Application No: R/253/20/HH
Site Address: 33 Knightscroft Avenue Rustington BN16 2HW
Description of works: Single storey annex building ancillary to main dwelling.

Thank you for your internet representation made on 21st December 2020 which has been recorded as an objection with the comments as follows:

PROPOSED PLAN 1:100

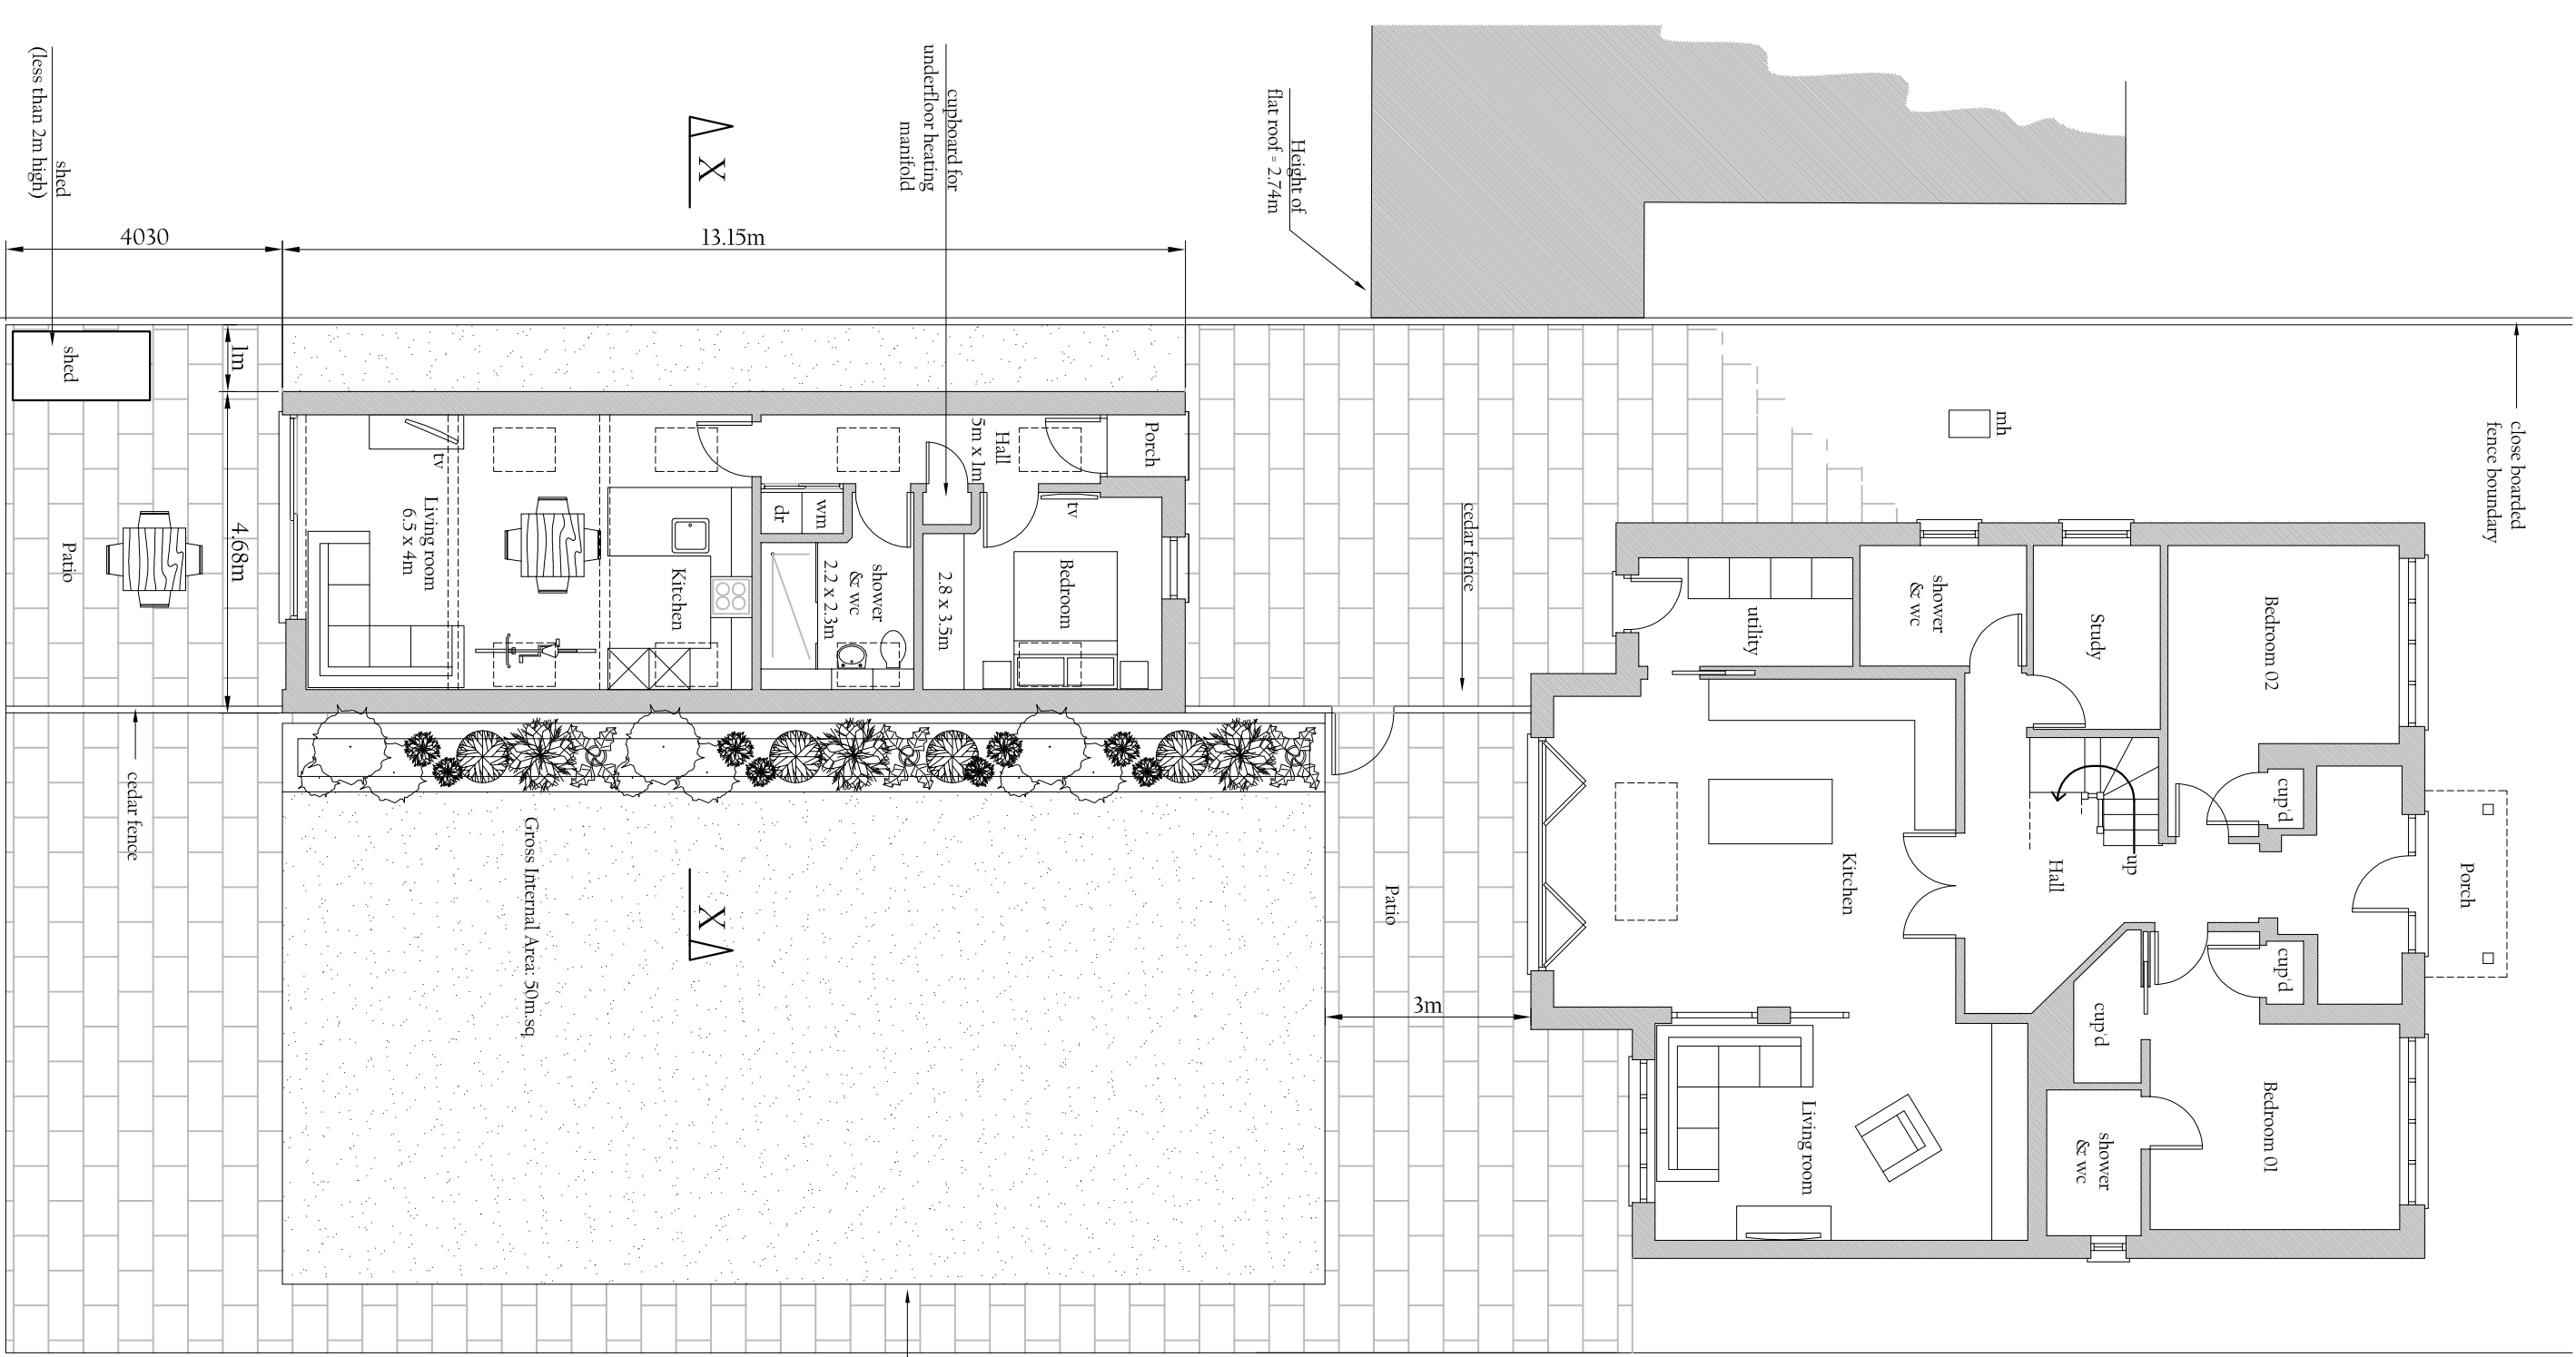
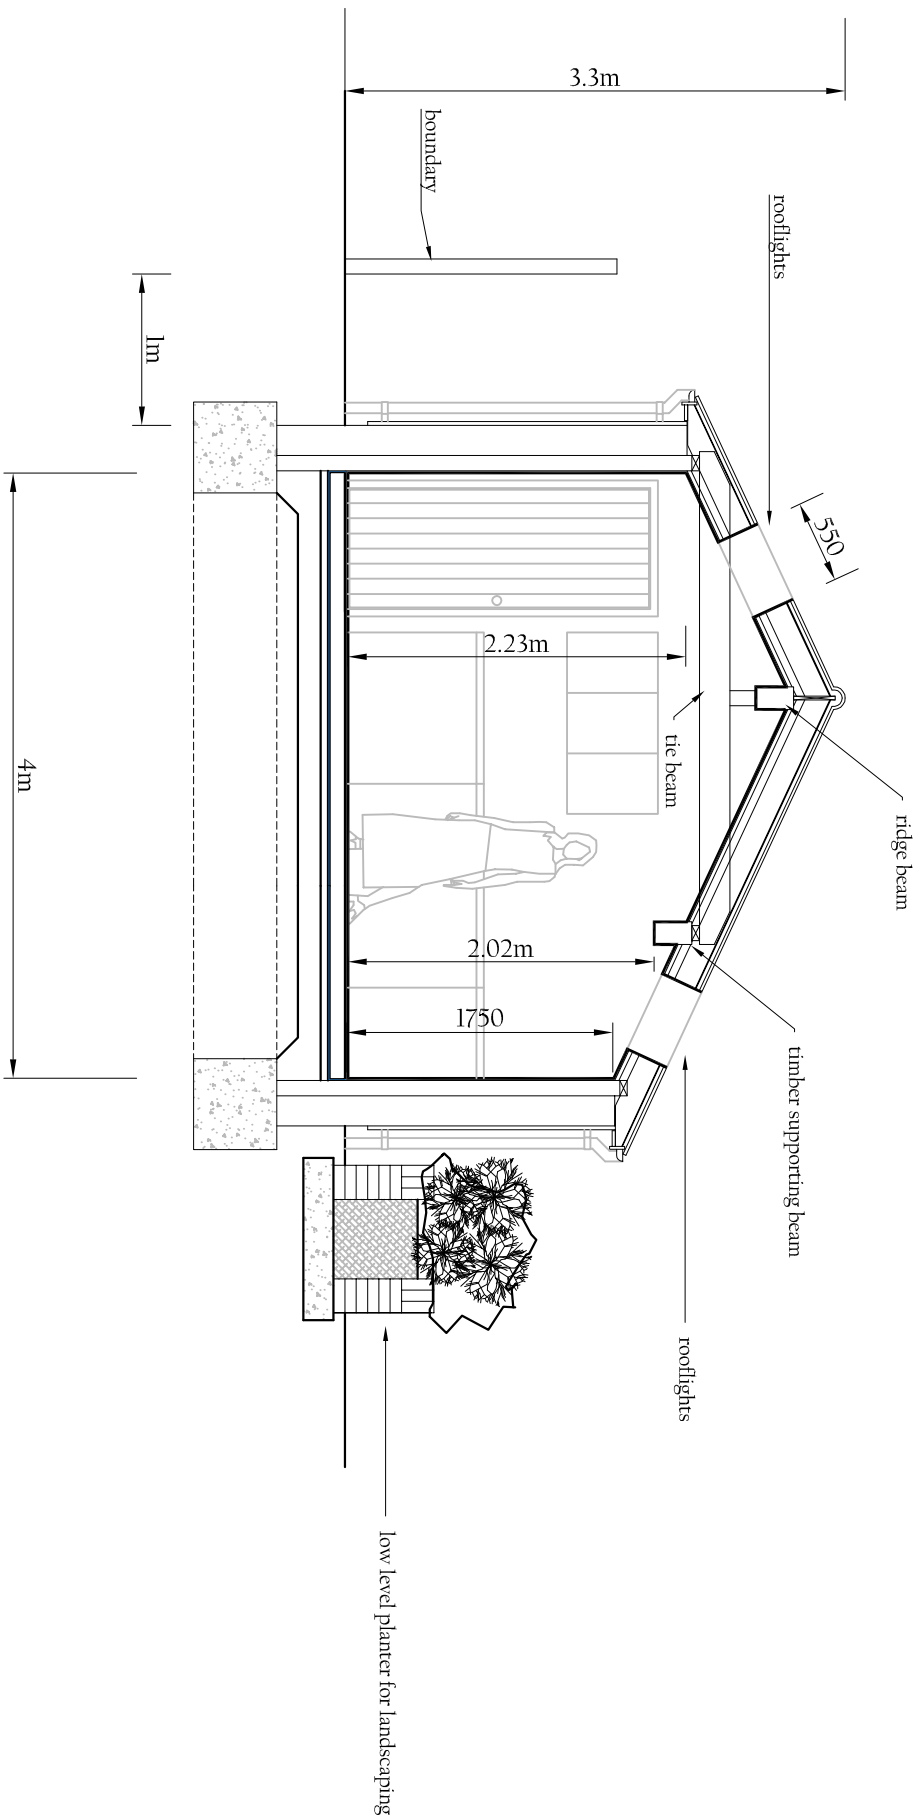
- 1) I live next door . The bungalow would run the length of their garden close to their fence . It will take my light.
- 2) I am concerned there would be increased footfall down the sideway.
- 3) There is a covenant covering the whole Cudlow Estate which states one dwelling per site.
- 4) I consider it will de-value my property and create more than the usual and acceptable noise in the garden.

6) I believe the close proximity of proposed bungalow to the St Bridgets Cheshire Home may well affect their light in what I understand are bedrooms.
